WELWYN HATFIELD BOROUGH COUNCIL – DEVELOPMENT MANAGEMENT
DELEGATED REPORT

APPLICATION No: S6/2014/1091/FP

SITE ADDRESS: Oak Cottage Residential Home, 4 Wilkins Green Lane, Hatfield

DESCRIPTION OF DEVELOPMENT: Erection of a rear extension

TITLE Proposed Roof Plan	
PROJECT NAME Oak Cottage, 4 Wilkins Green Lane, Hatfield, AL10 9RT	
DRAWN BY E.B	DATE MARCH 2014
SCALE 1:100 @ A3	CHECKED
DRAWING NO. EL/2012/10	REV. NO. G

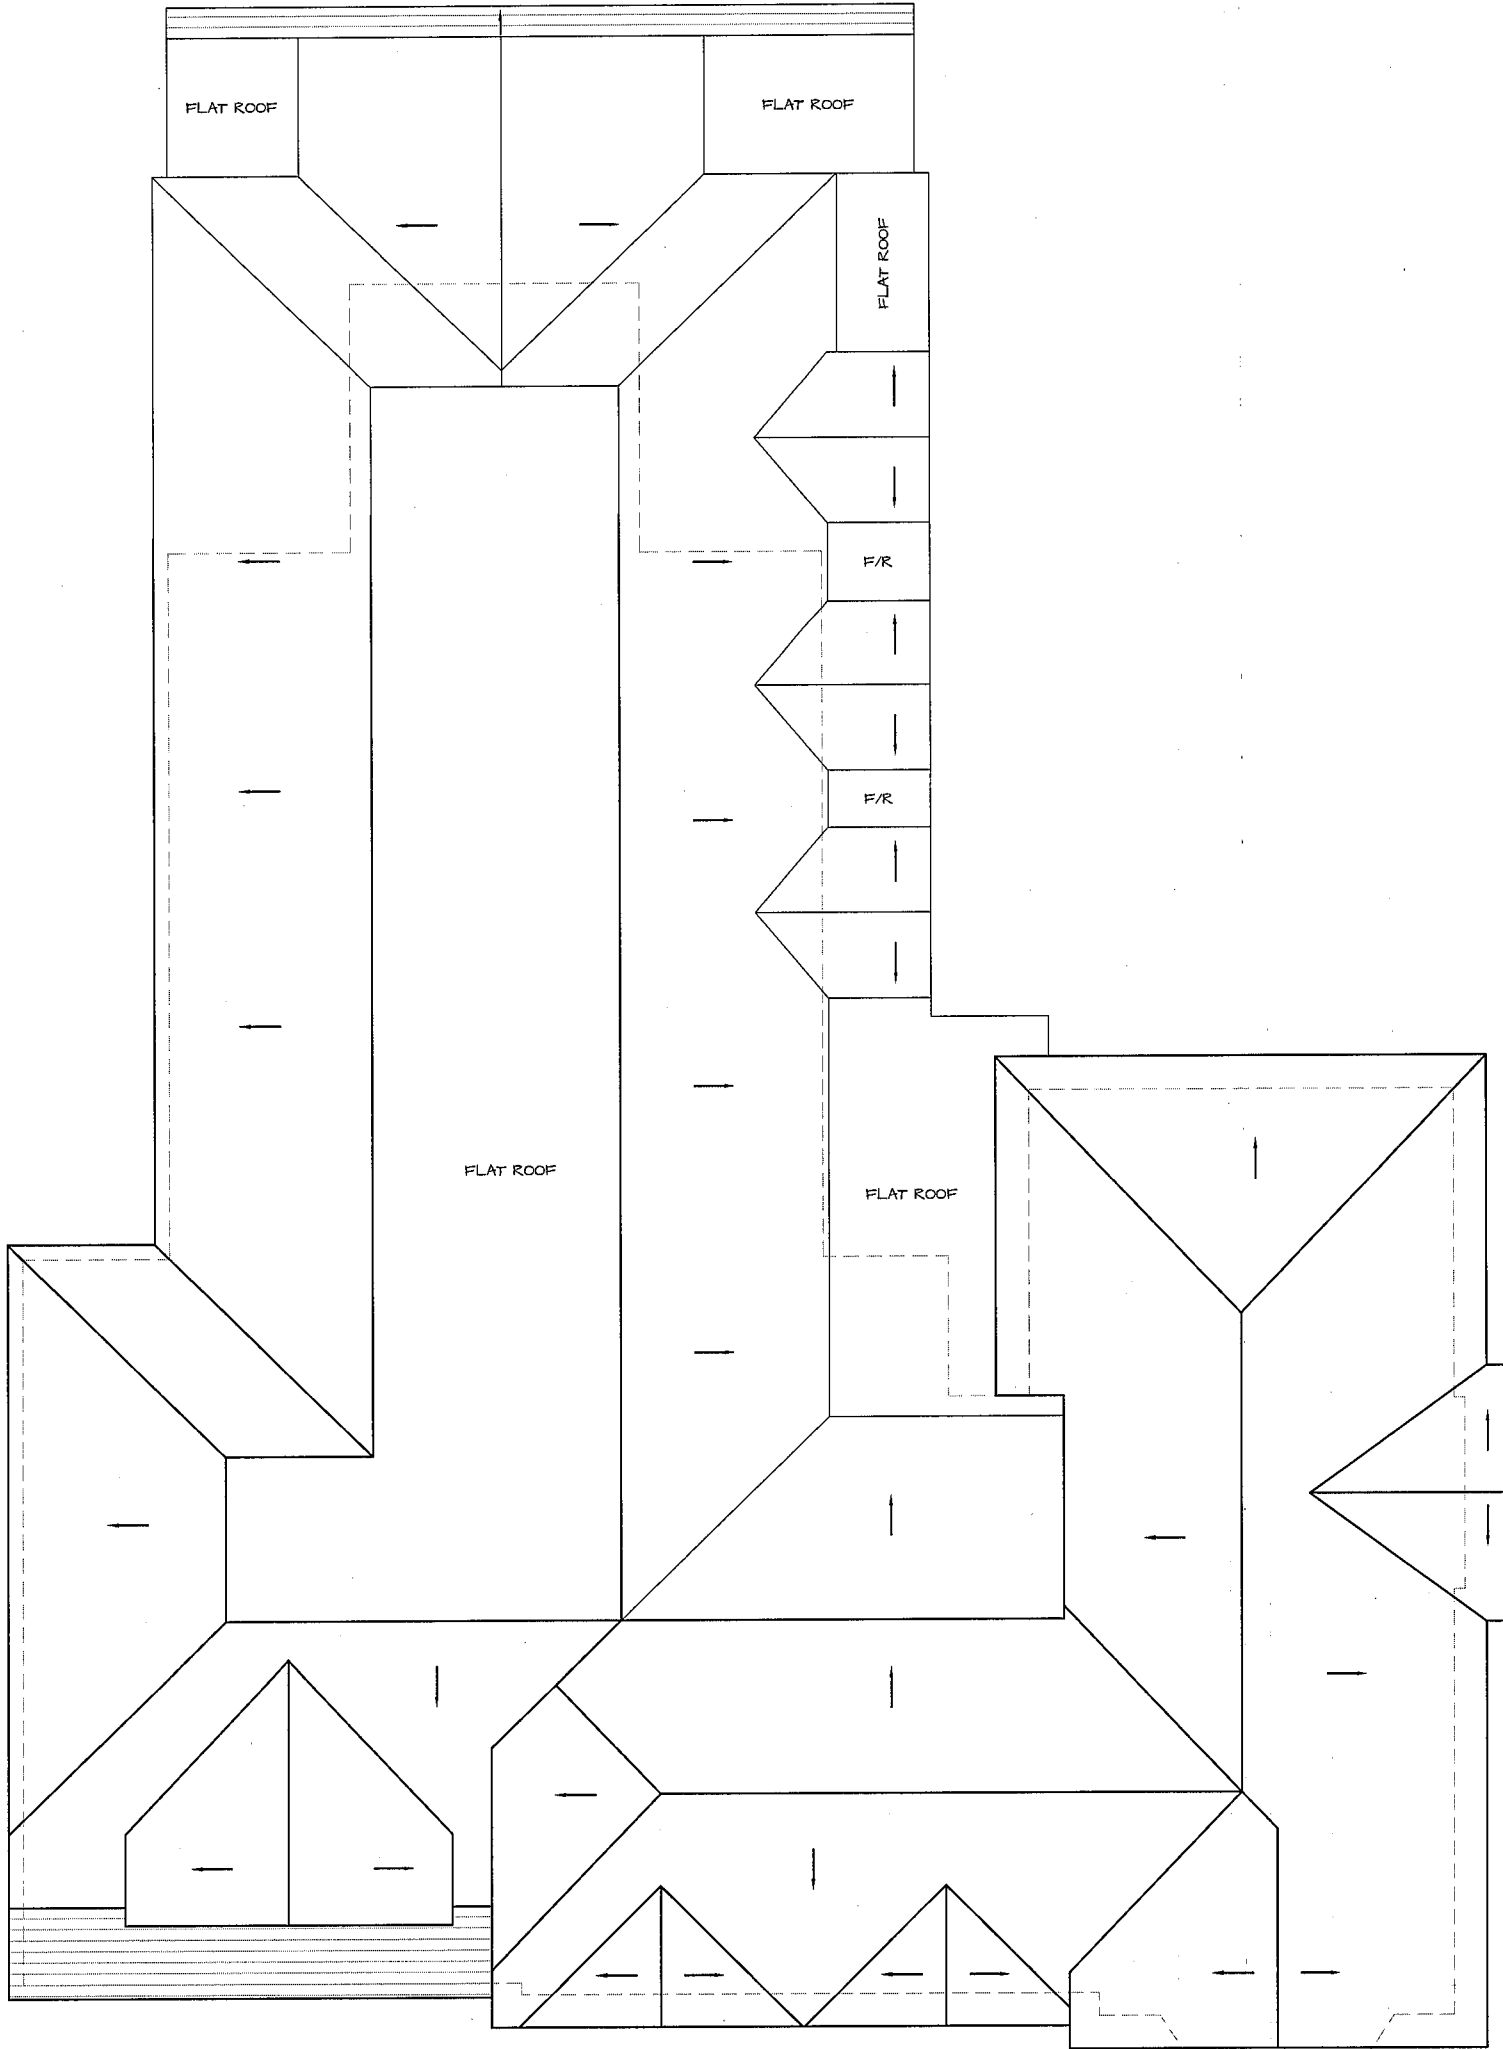
The depth of the original building measured approximately 9.9m along its west elevation. Cumulatively, this proposal would result in a rear extension measuring 17.1m, increasing the total depth of the building to 27m. This is a substantial increase by any measure and when considered cumulatively with the existing extensions, the proposed development would fail to remain subordinate in scale to the original building. The apparent size of the extension would be accentuated by its bulky and poorly proportioned design. In visual terms, whilst the extension is set in from the flank wall of the original building, there is very little articulation along its length to break up its bulk and massing. Some attempt has been made to reduce the scale of the first floor and roof by setting it in 500mm across the rear and by adding a gable element, however, the benefits of these elements is limited given the overall scale of the extension. In terms of quality of design, these features would appear crude and contrived given that the gable feature would be flanked by flat roofs at first floor level and the pitch of the lean to roof would not match the main roof.

The existing building is characterised by a hipped roof with feature gables above some windows. Whilst there is a section of flat roof in a corner between the main dwelling and the rear extension, this is a small infill area which is well concealed. More importantly, its existence does not demonstrate that this type of development is worthy of repetition, in fact quite the opposite. Repetition of this type of development would fail to respect or relate to the original building and would have a deleterious effect on its character and appearance.
